From: Tom Errico <thomas.errico@tylin.com>
To: Jean Fraser <JF@portlandmaine.gov>
CC: David Margolis-Pineo <DMP@portlandmaine.gov>, Katherine Earley <KAS@port...>
Date: 4/11/2014 3:27 PM
Subject: Westgate Shopping Center - Dunkin Donuts

Jean - I have reviewed the traffic information associated with the introduction of a Dunkin Donuts at the former Tim Horton's restaurant and offer the following preliminary comments. I would note that based upon MaineDOT traffic methods, a Dunkin Donuts generates significantly more traffic as compared to a Tim Horton's and therefore additional traffic impacts can be expected from the project.

Drawing file: Plans / P8 Stacking Plan.pdf

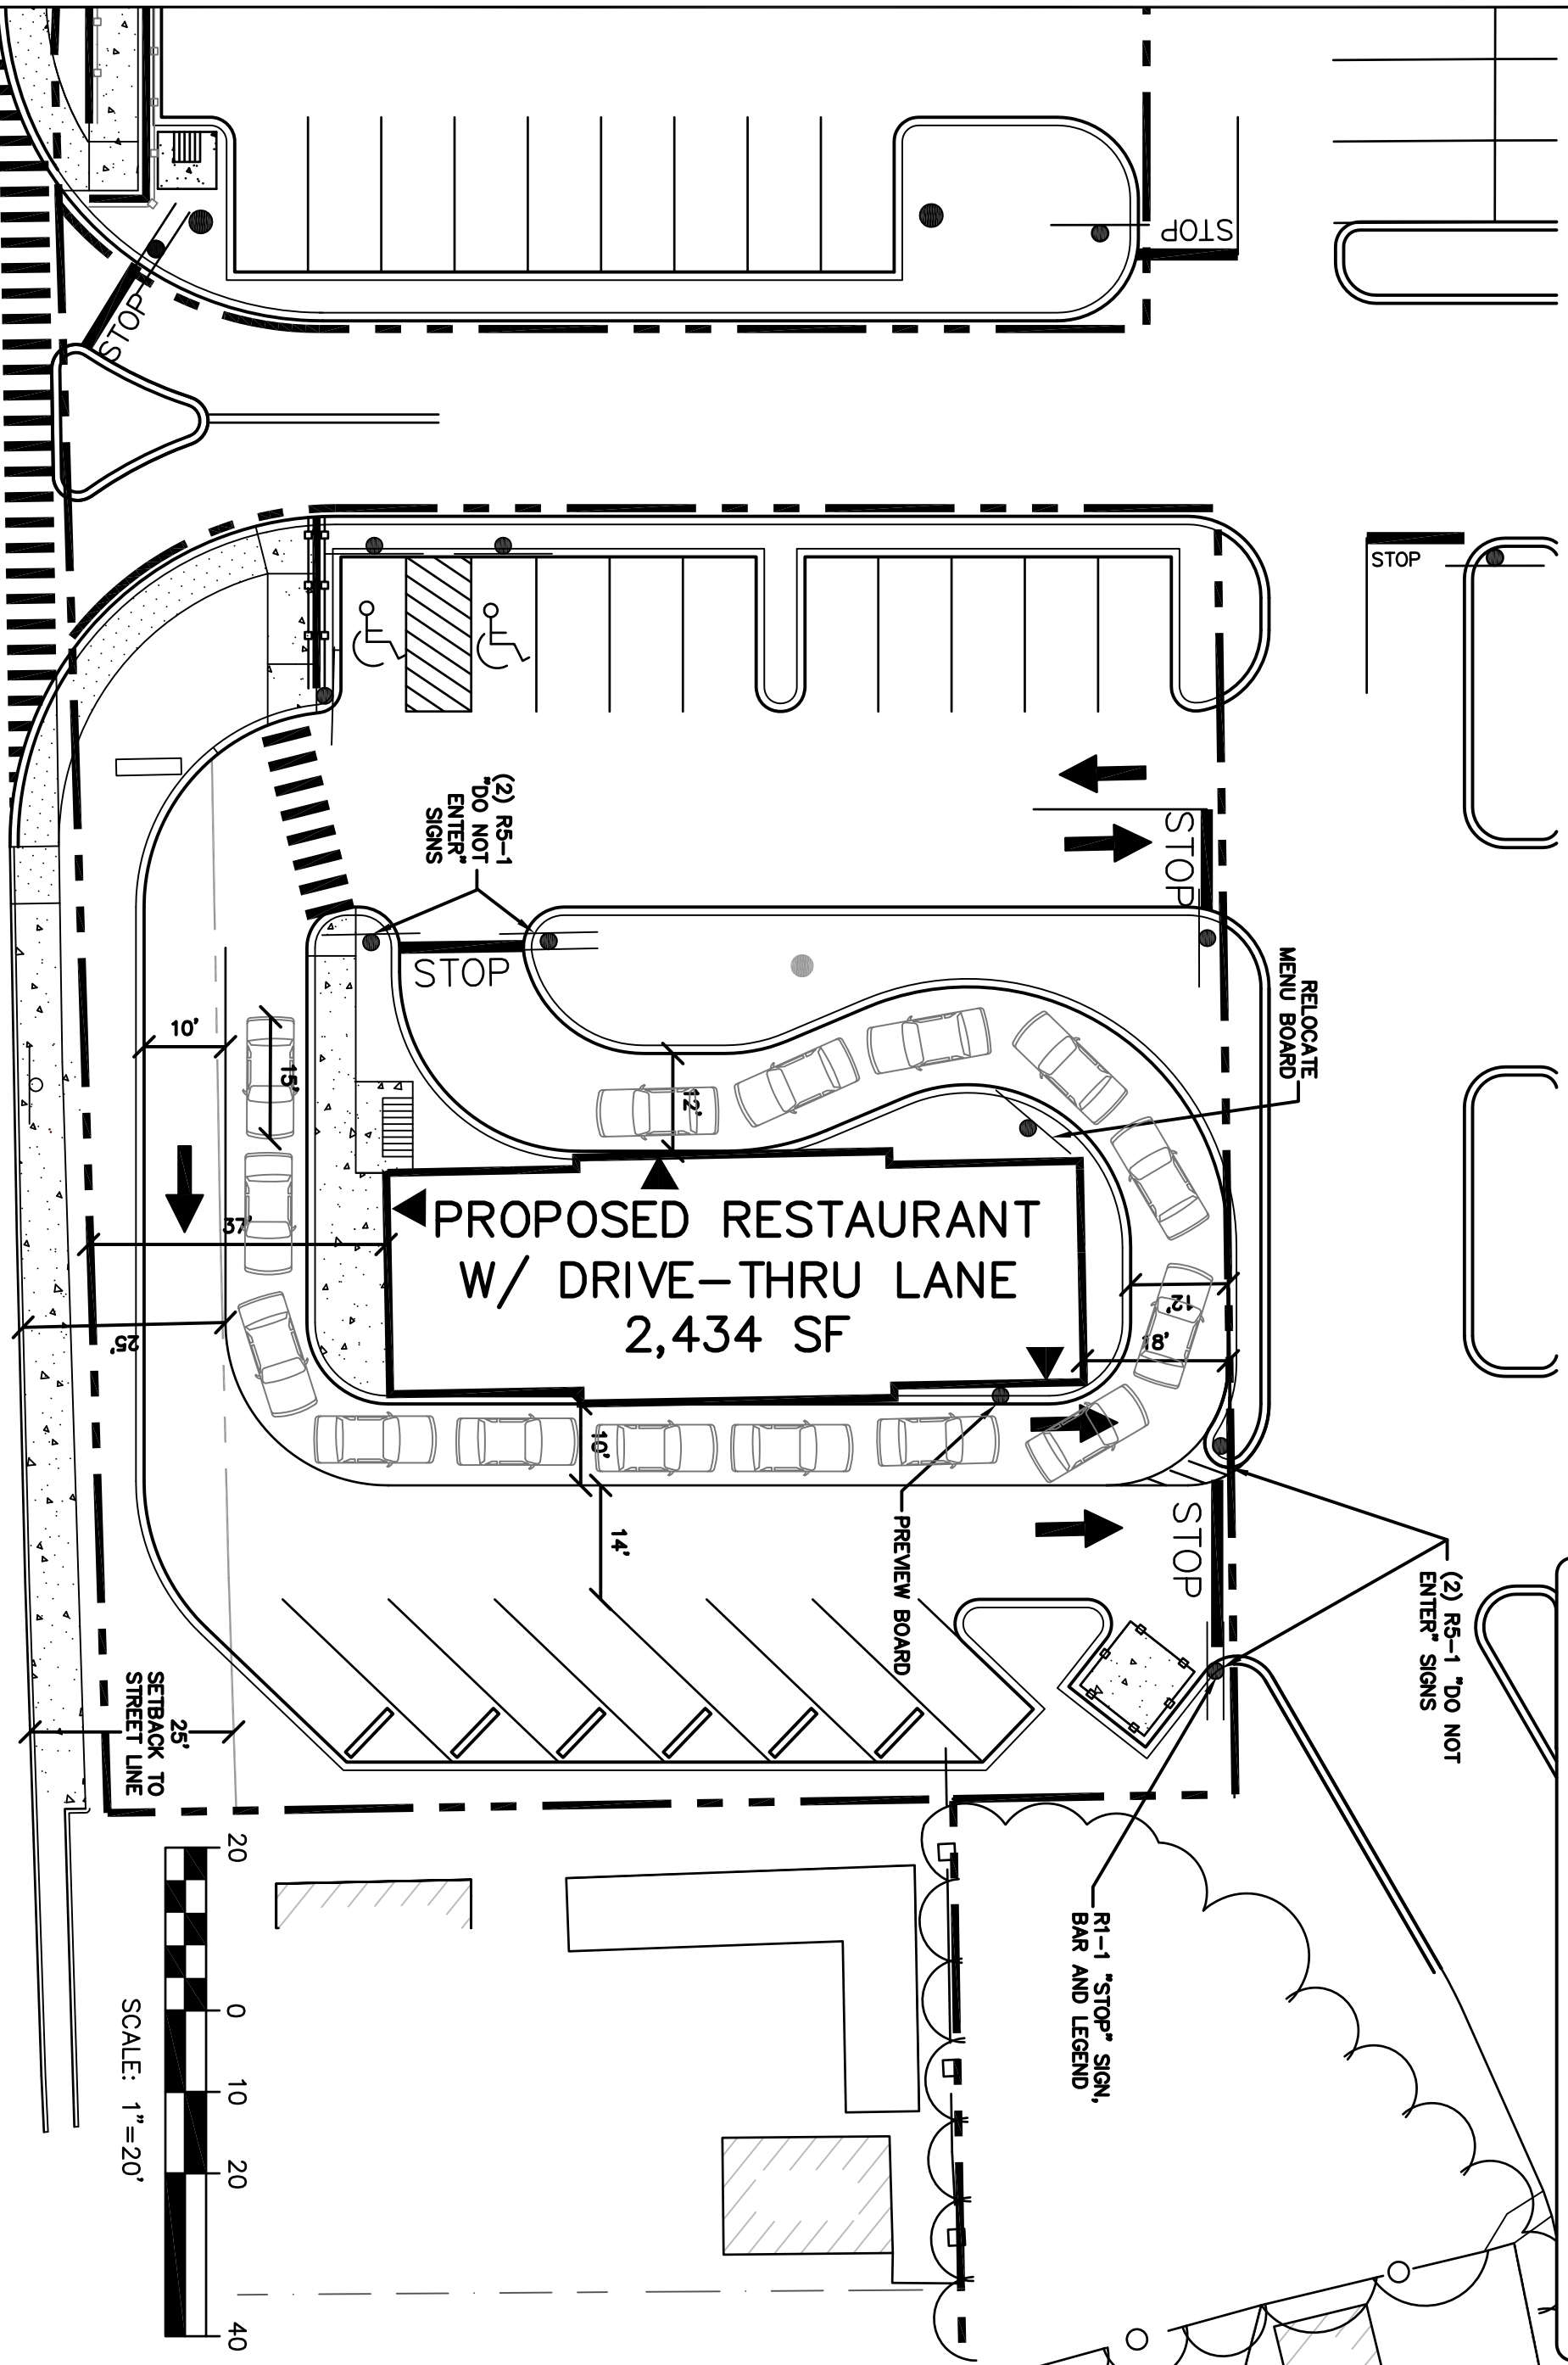
* I have conducted a review of vehicle queuing at the drive-through. According to established queue estimates developed by MaineDOT, for use in the permitting of Dunkin Donuts in Maine, the design queue length is 15 vehicles from the pick-up window and 12 vehicles from the Order Board. I had a conversation with Steve Landry, MaineDOT State Traffic Engineer, regarding this issue and he concurred that the MaineDOT method should be used. Based upon this method, vehicle queues will extend along the front of the building (facing Congress Street). I would note that from a traffic circulation perspective, this queue length does not present any safety or operational problems.
